**RE: ABP-318758-23 – WESTGATE 2040, DROGHEDA, CO. LOUTH – PUBLIC REALM REGENERATION WORKS**

This letter has been prepared by Turley Planning Ireland Ltd and members of the wider Westgate Design Team, on behalf of Louth County Council, in response to An Bord Pleanála's (hereafter 'the Board') recent request to make submissions or observations in relation to the 11 no. submissions received by the Board during the public consultation stage of the Westgate 2040 planning application process.

DRAWING
Demolition Plan -
Toilet Block at George's Square

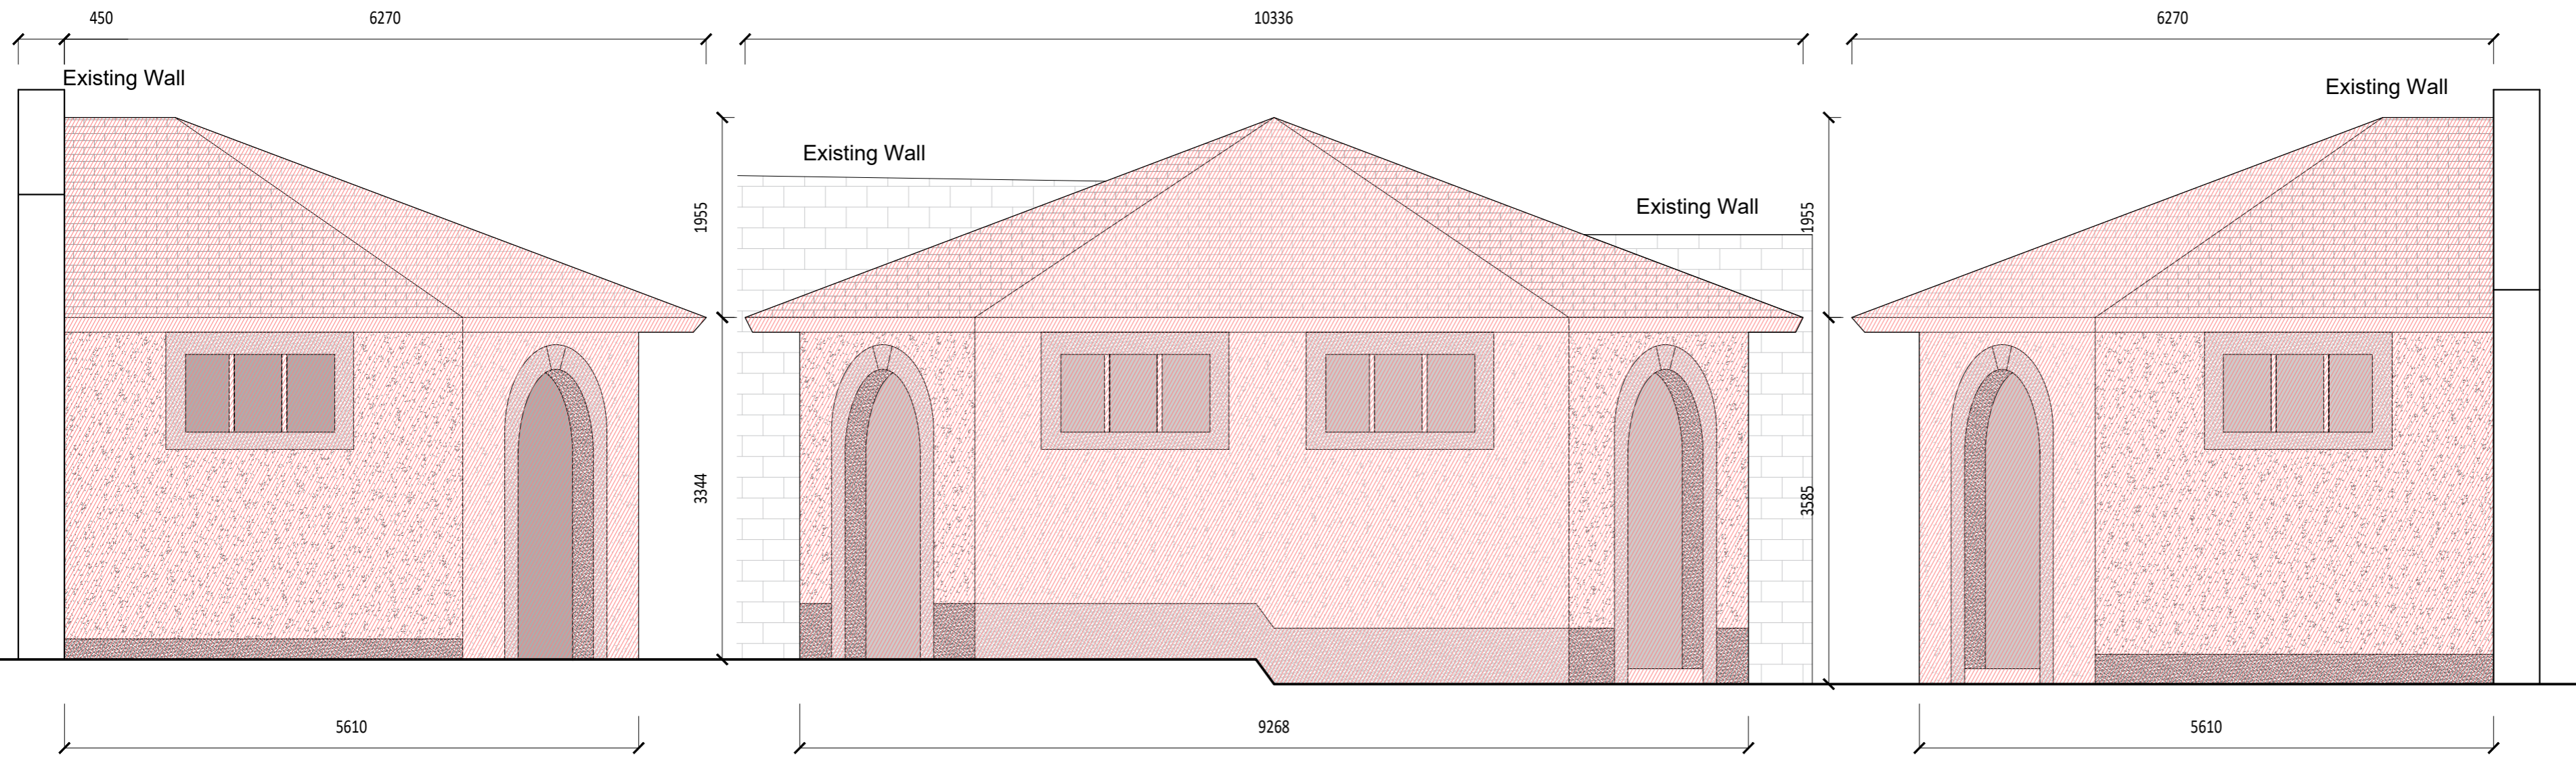
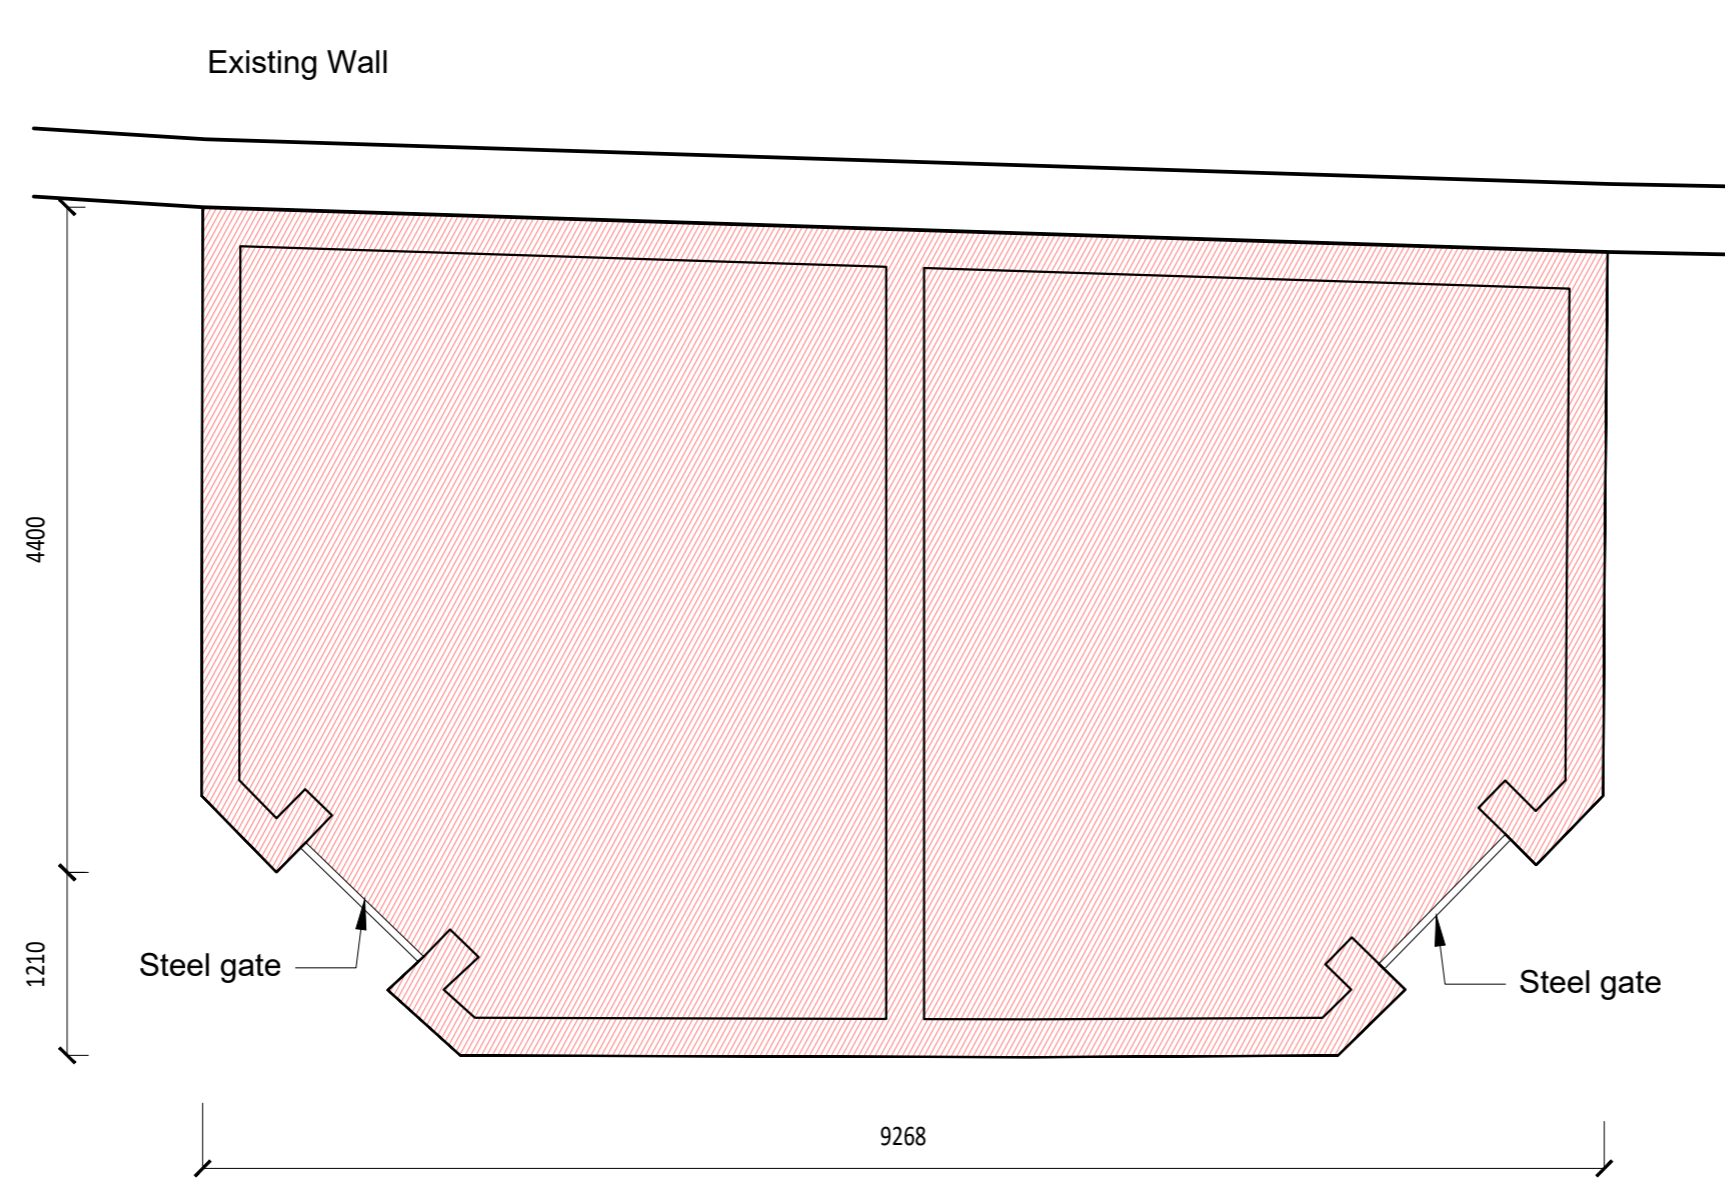
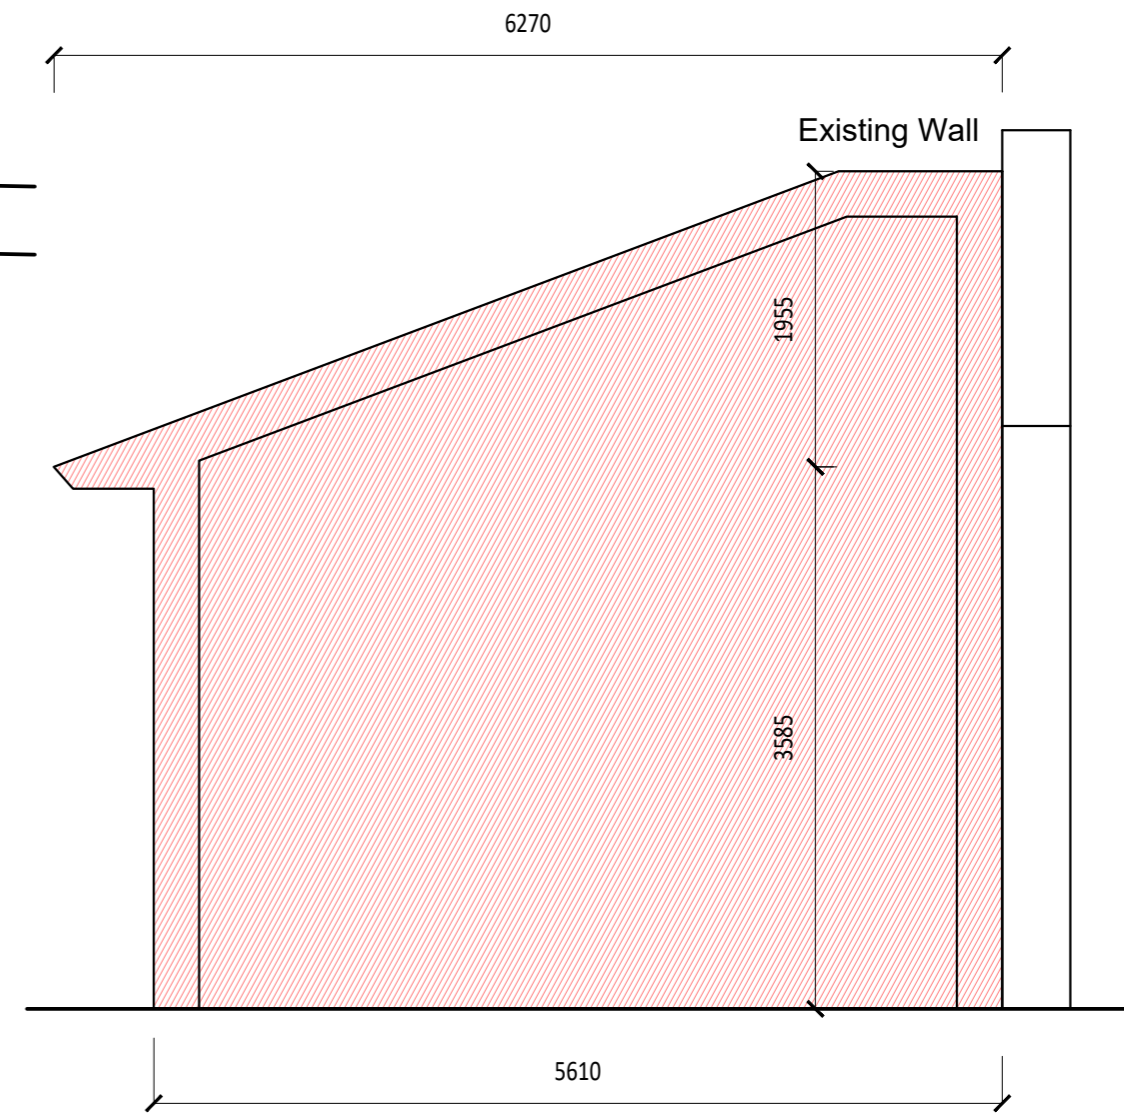
## (X) PUBLIC TOILETS

The existing public toilet block located within George's Square were closed c. 2019 due to safety, repeated anti-social behaviour and maintenance issues. The Design Team reviewed the potential to retain the toilet block, however, this was not possible noting the difficult topography levels within George's Square, the large footprint of the toilet block, the requirement to deliver a high-quality arrival/gateway area within George's Square, the requirement to provide universal (Part M) access within George's Square and the requirement to enhance functionality of the areas located adjacent to the existing businesses/building line.

It is further noted that more modern, safe and accessible public convenience solutions with smaller footprints are available which could be installed at a suitable location in the future, if required. Louth County Council will continue to monitor public conveniences available within the Westgate area and wider Drogheda Town Centre following implementation of the proposals.
